# SUNNICA ENERGY FARM

8.44 Applicant's Response to Local Impact Report – Response to  
Annex E and Annex F

<b>Version</b>	<b>Date</b>	<b>Status of Version</b>
Rev 00	28 November 2022	Deadline 3A Submission

SUNNICA WEST SITE A,
SITE ACCESS A (SW-A)
LA HOGUE ROAD (1 OF 3)

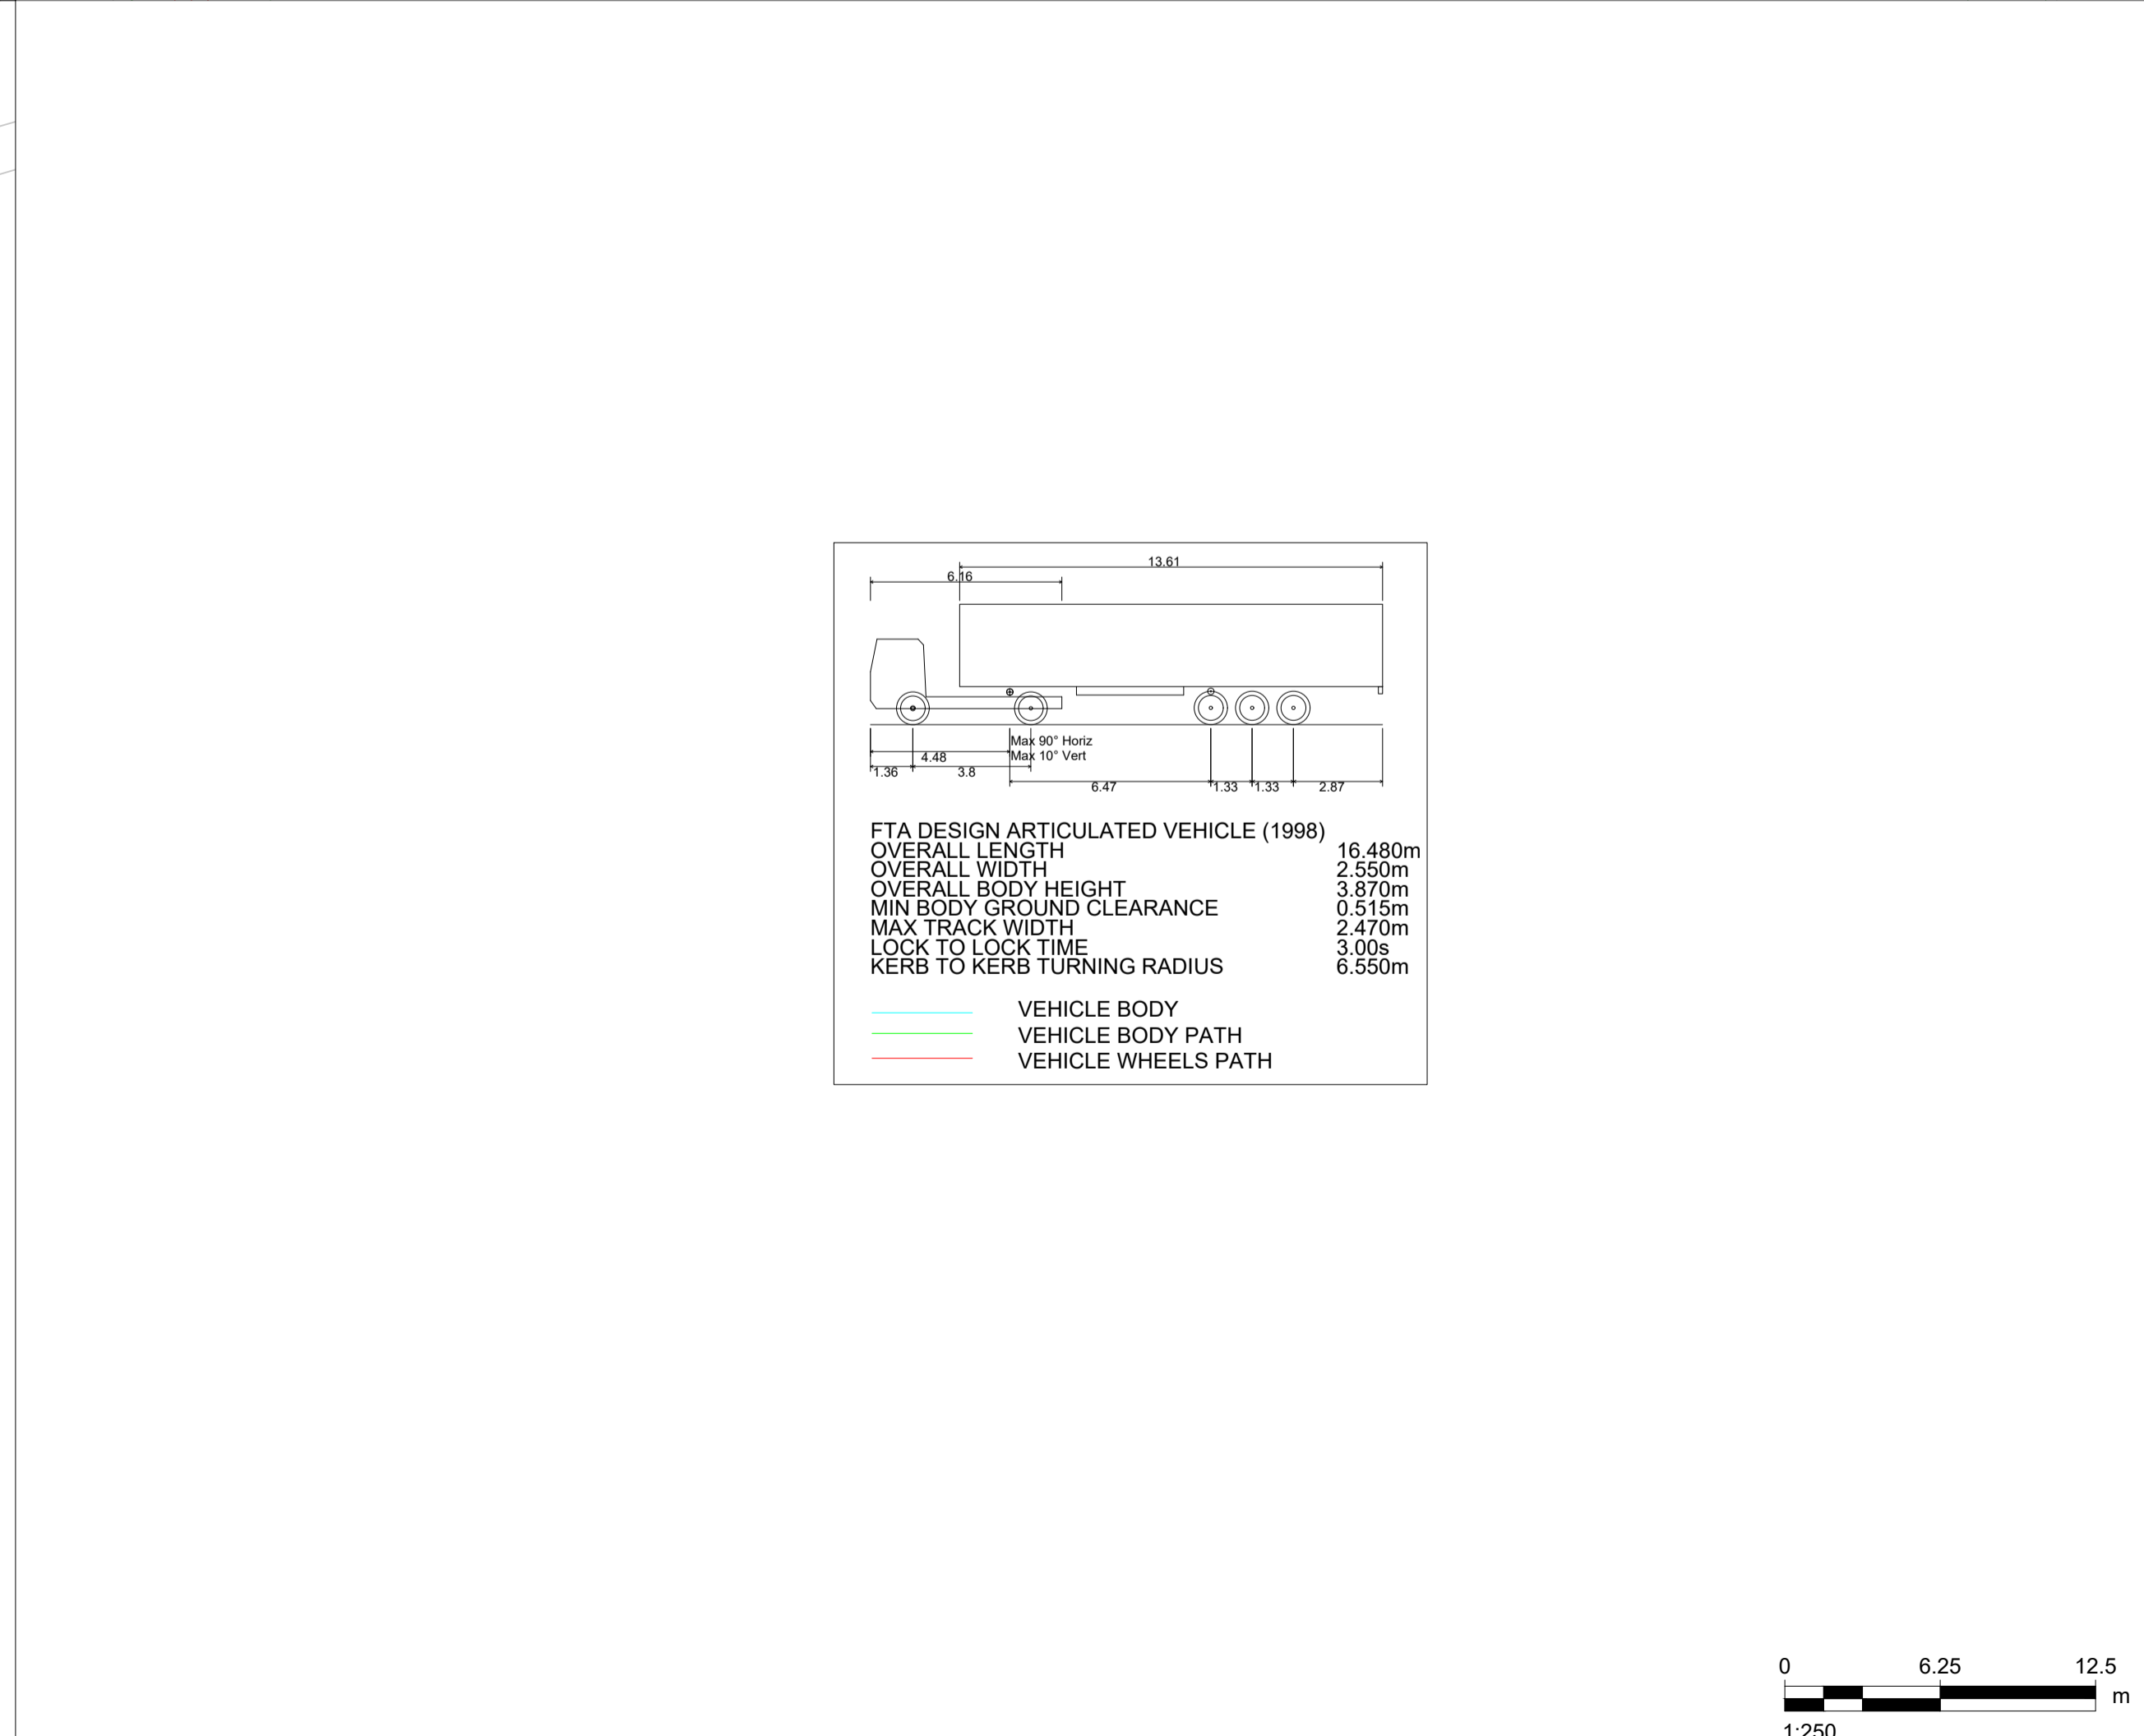
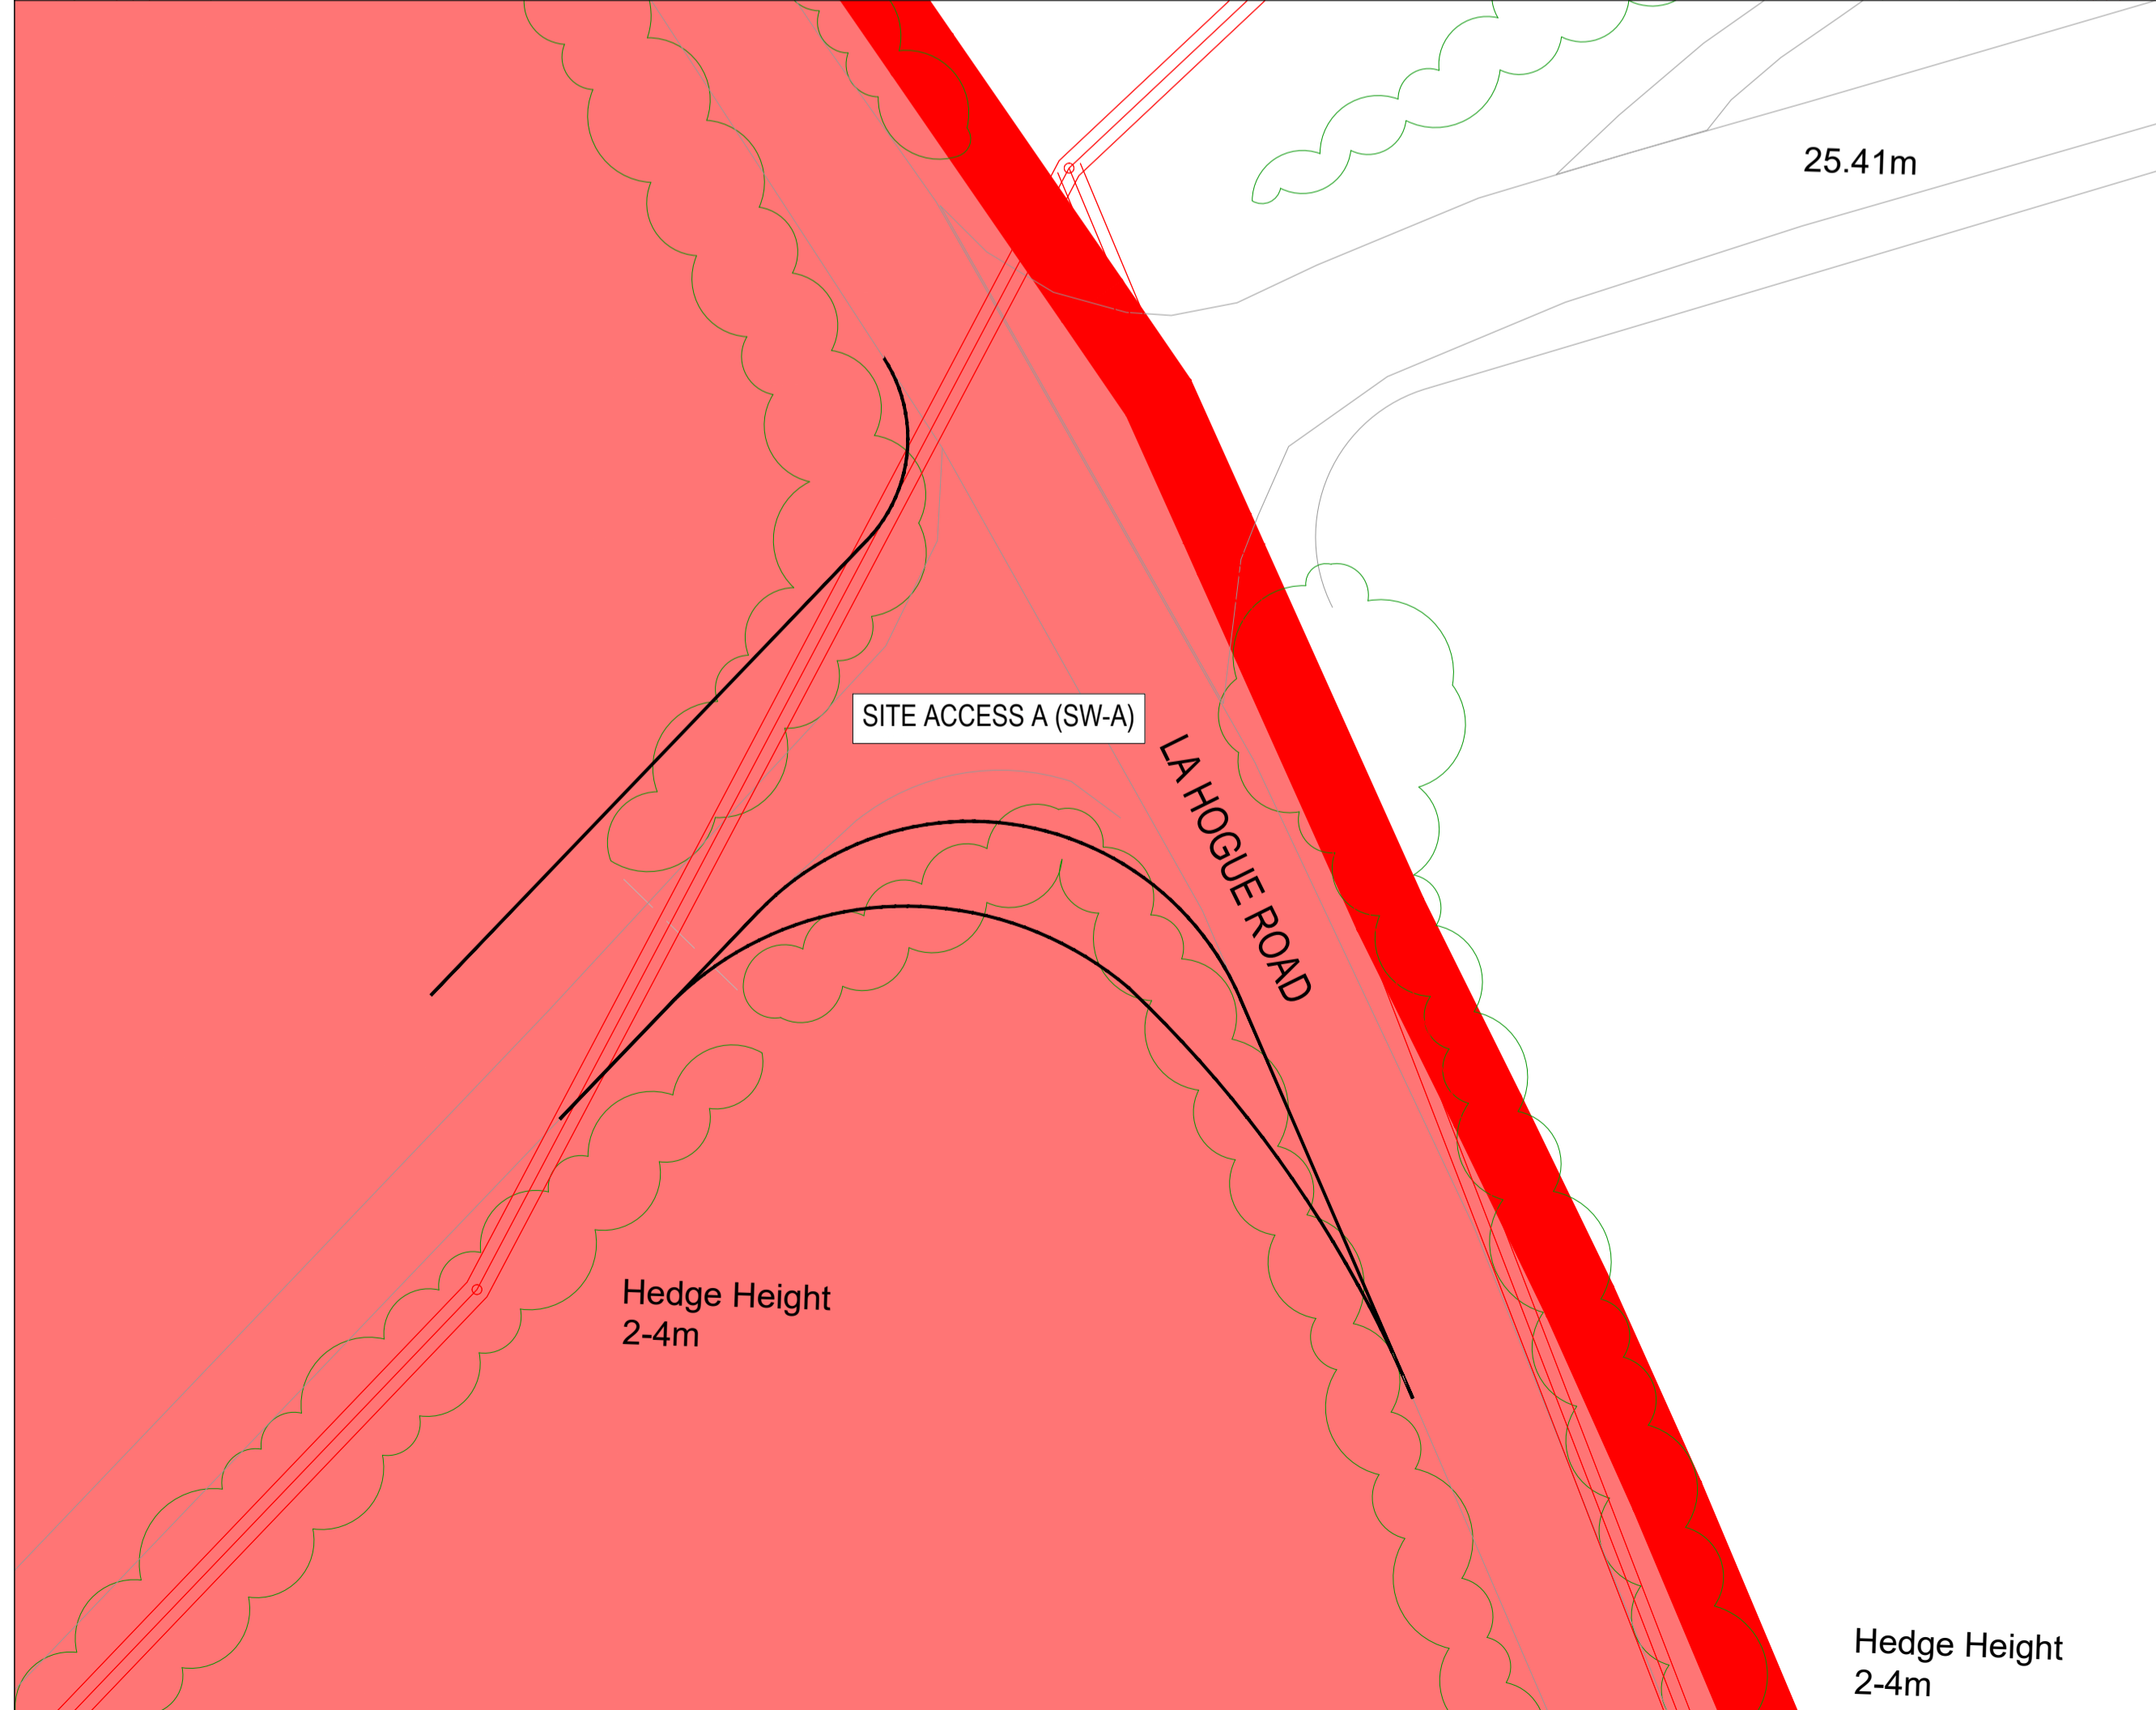
E.14-E.19	Comments on Individual Accesses Sunnica West Site A: Site Access A on La Hogue Road	<p>It should be noted that this access is in the location of an existing site access opposite the farm shop. The full visibility splay will be provided during the construction and operational phase of the scheme within the Order limits and is shown in the next iteration of the Framework Construction Traffic Management Plan and Travel Plan the Applicant submitted at Deadline 3A. The construction staff will arrive on site before 7am and leave site after 7pm, as per paragraph 7.2.26 in the Framework Construction Traffic Management and Travel Plan [REP3-013]. This is outside of the opening hours of the farm shop, and therefore there will be minimal interaction between traffic using the site access and traffic using the farm shop during the construction period.</p> <p>It is noted the comment made regarding the provision of the visibility splay on the loss of hedgerow. This has been assessed from a Landscape and Ecology perspective in the Environmental Statement [APP-40].</p> <p>As previously stated, the Applicant has noted comments from the LHAs regarding the information provided in the site access plans. A draft set of site access drawings has been prepared and provided to the LHAs. The set of drawings provided to the local highway</p>

LIR Summary Reference (Para)	Summary of LIR Comment	Applicant's Response to LIR
		<p>authorities are to be provided within the next iteration of the Framework Construction Traffic Management Plan and Travel Plan submitted at Deadline 3A. A further meeting was held on 24/11/22 to discuss each of the site access proposals with the outcomes of discussion intended to be reported within the relevant Statement of Common Ground.</p> <p>Other points in relation to design information are set out in response to Chapter 13 points 1g to 1w. The level of information available is proportional to the stage of the project with detailed design of the site accesses to be provided at a later stage, prior to construction. The detailed design of site accesses is required to be submitted for the approval of the relevant planning authority prior to the commencement of the project in accordance with requirement 6 contained in Schedule 2 to the draft DCO.</p> <p>The radius has been identified based on the swept path analysis of a 16.5m articulated HGV and a 46.63m AIL. Therefore, it is considered the radius to be appropriate for the purpose of use. The radius to the north of the junction is not proposed to be modified as large vehicles will not be required to access from the north of La Hogue Road as this is not on the HGV route identified within, and secured by, the Framework Construction Traffic Management Plan and Travel Plan [AS-300, AS-301].</p> <p>The swept path analysis of two-way vehicle movement at the staff car parks is provided in the iteration of the Framework Construction Traffic Management Plan and Travel Plan the Applicant proposes to submit at Deadline 3A.</p>
